CITY OF ALBUQUERQUE

February 20, 2019

**RE: Aloha RV Expansion
8212 Pan American Fwy NE
Grading and Drainage Plan
Engineer's Stamp Date: 2/6/19
Hydrology File: C18D104**

Based on the submittal received on 2/8/19, the Grading and Drainage Plan cannot be approved until the following are corrected:

ALOHA RV  
8212 PAN AMERICAN FWY, NE  
GRADING PLAN

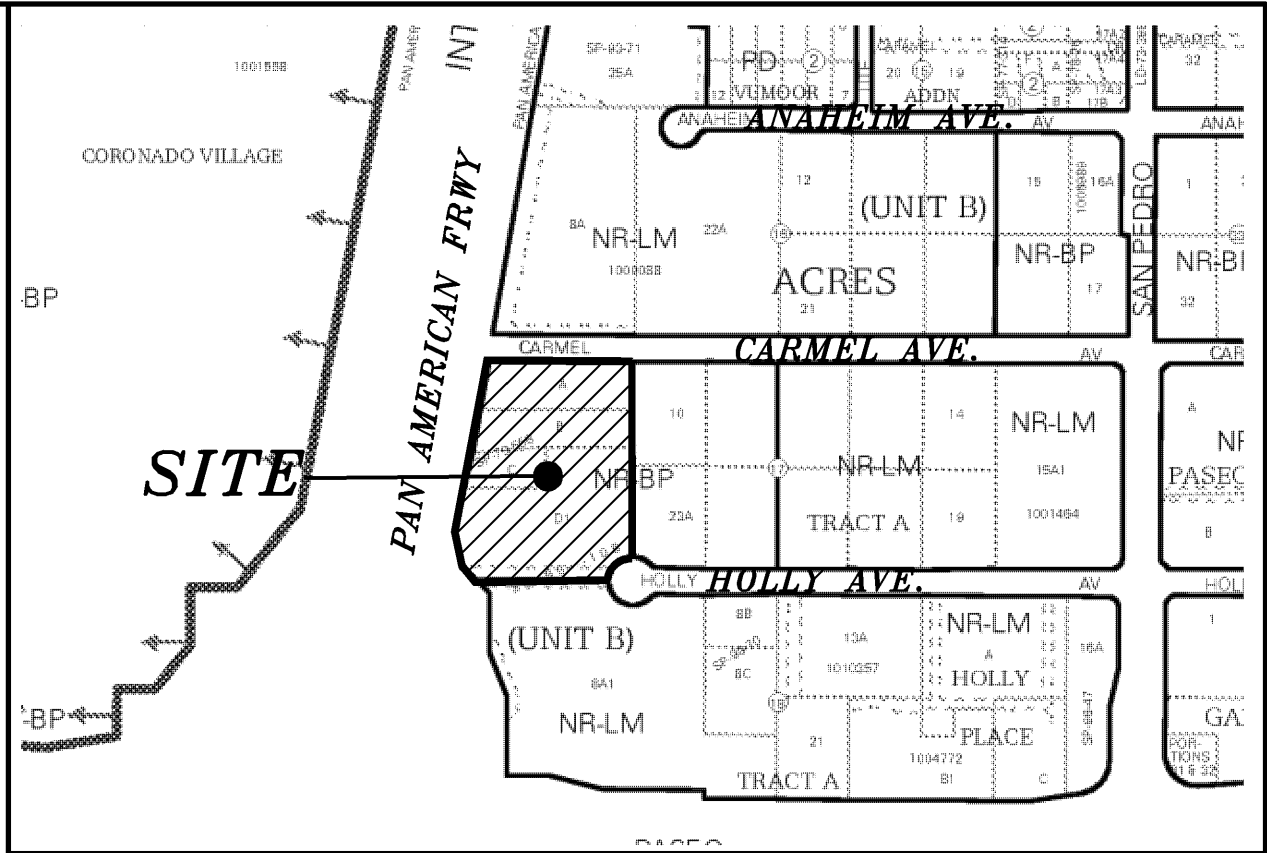
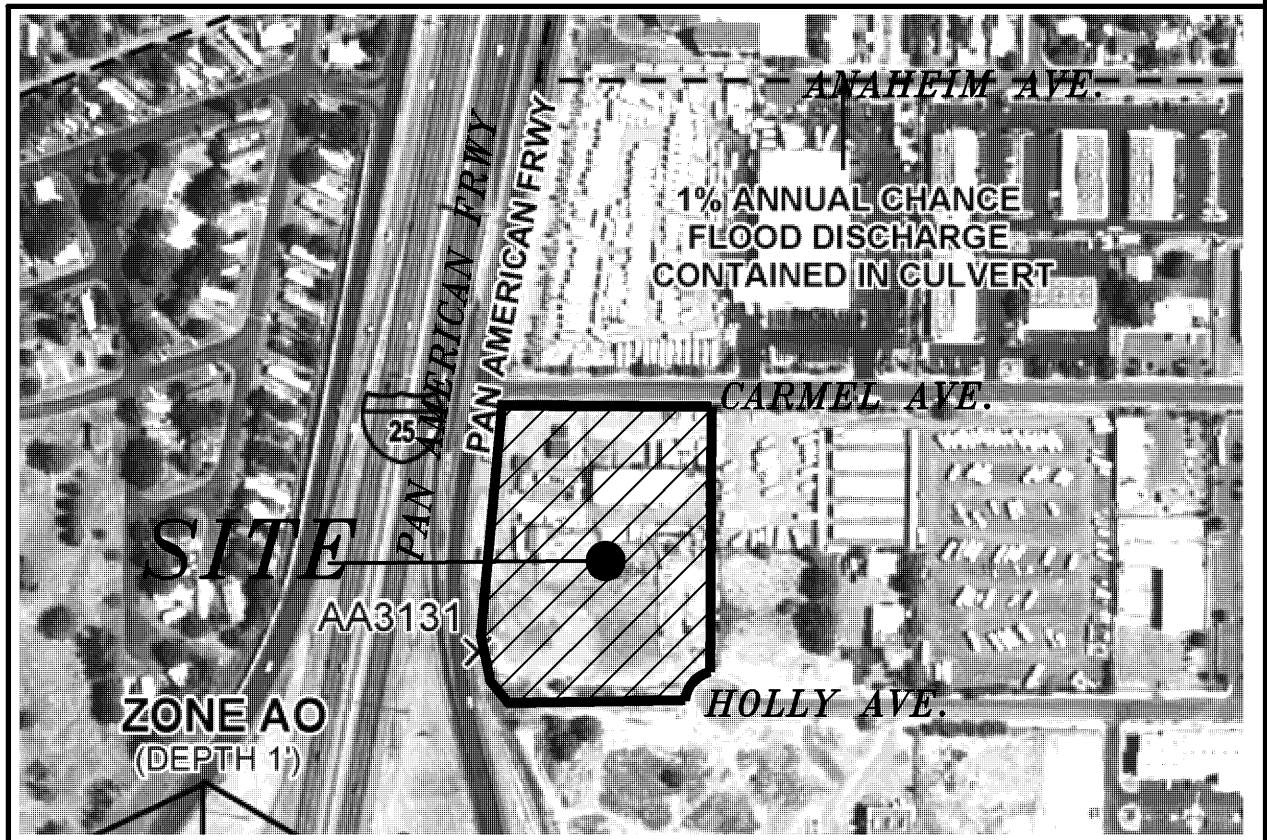
1. Allowable discharge for this area is 3.14cfs/ac (not 3.41), including paved frontage on Holly and Carmel. When determining your site's allowable discharge, be sure to deduct the frontage to the centerline, which free-discharges.

2. Proposed contours need to tie-in at the property line; relook along the west side of your site. The proposed contours also seem to ignore the presence of curbs and pond A seems to encroach on the drive aisle.

3. Delineate and provide the area of new paving; Paving Permit approval likely needs to be requested as well. Show how the areas of new paving will be routed into a storm water quality pond (curbcut and rundown into pond A?).

4. Basins need to be delineated, and the ponds sized for the areas draining to them. Increased discharges or modified discharge points to the NMDOT ROW will require their approval.

5. Pond details are lacking. Pond volume calculations need to determine the surface area and associated volume by each contour. The pond B volume calculation doesn't match the callout on the plan. Provide primary and emergency spillways for the ponds, supported with hydraulic calculations and include freeboard.

7. This project requires an ESC Plan, submitted to the Storm Water Quality Engineer (Curtis Cherne PE, ccherne@cabq.gov or 924-3420).
8. "Calculations" references an AHYMO Model which is not provided.

9. Include project benchmark and datum.
10. Add note on the plan that "No work shall be performed in the public ROW without an approved Work Order or Excavation Permit."
